**Consultation Response from KC,
Lead Local Flood Authority**

2024/92576 site of, Former Spotted Cow Pub, New Hey Road, Oakes, Huddersfield, HD3 4BU

Discharge of details reserved by conditions 3 (CMP), 21 (retaining walls), 23 (surface water) and 28 (non-native species) of previous permission 2021/94029 for demolition of existing structures and erection of foodstore (class E) with associated access, parking, servicing areas and landscaping

Date Responded: 25th October 2024

TYPICAL STORMBLOXX ATTENUATION SYSTEM BY ACO OR SIMILAR APPROVED

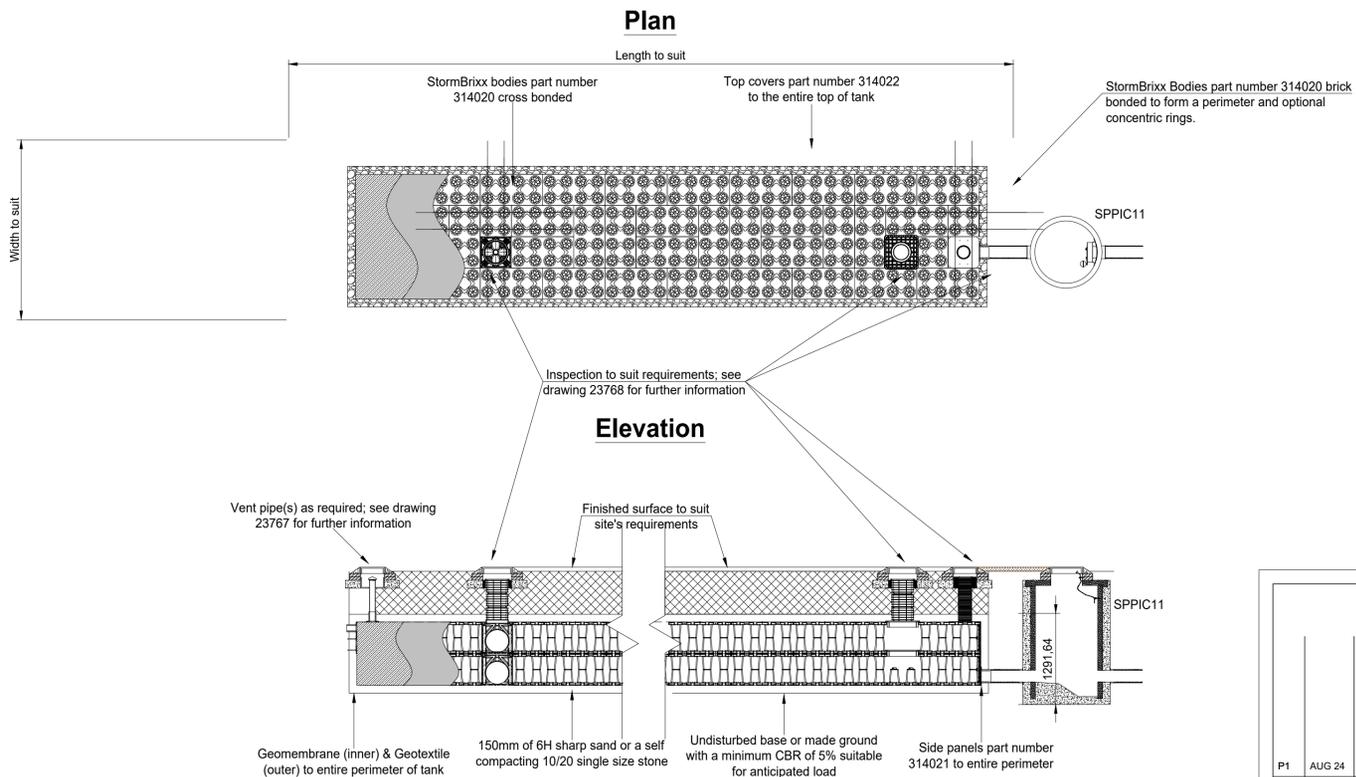
Cellular storage is not recommended for major applications due to the LPA's obligation to ensure effective maintenance and management of SUDS. Other systems allow internal inspections for both siltation, deformation, and failure and are easier to clean.

However, the use on commercial sites has been allowed by Kirklees Council in the past and is treated differently from residential developments. A specific manufacturer must be selected, and the product presented in plan and cross section form. A full bespoke maintenance plan must be produced that includes a replacement period. This must be based on CDM regulations and provide a method statement including itinerary and schedule of tasks. This will be extended to the flow control device. Any removal of the flow control device should state that the neoprene seal will be replaced at this juncture.

In our experience, manufacturers do not offer any guarantees on longevity of the product itself, although they may do so on installation defects, such as sealing the membrane. Without carrying a British Standard or Water Industry Standard, there is no standard certification relating to longevity. It has been noted that BBA certification is applied to some products, and these might suggest an estimated lifespan only. With the inability of most products to be routinely cctv surveyed for defects, unlike boxed culverts and oversized pipes, an arbitrary lifespan is required. Unless evidence can be provided to the contrary, these products must be replaced after 25 years. This must be included in the maintenance and management plan. Where failure of the product is suspected, then excavation and replacement will come sooner.

We do NOT recommend that this condition is discharged at this moment in time.
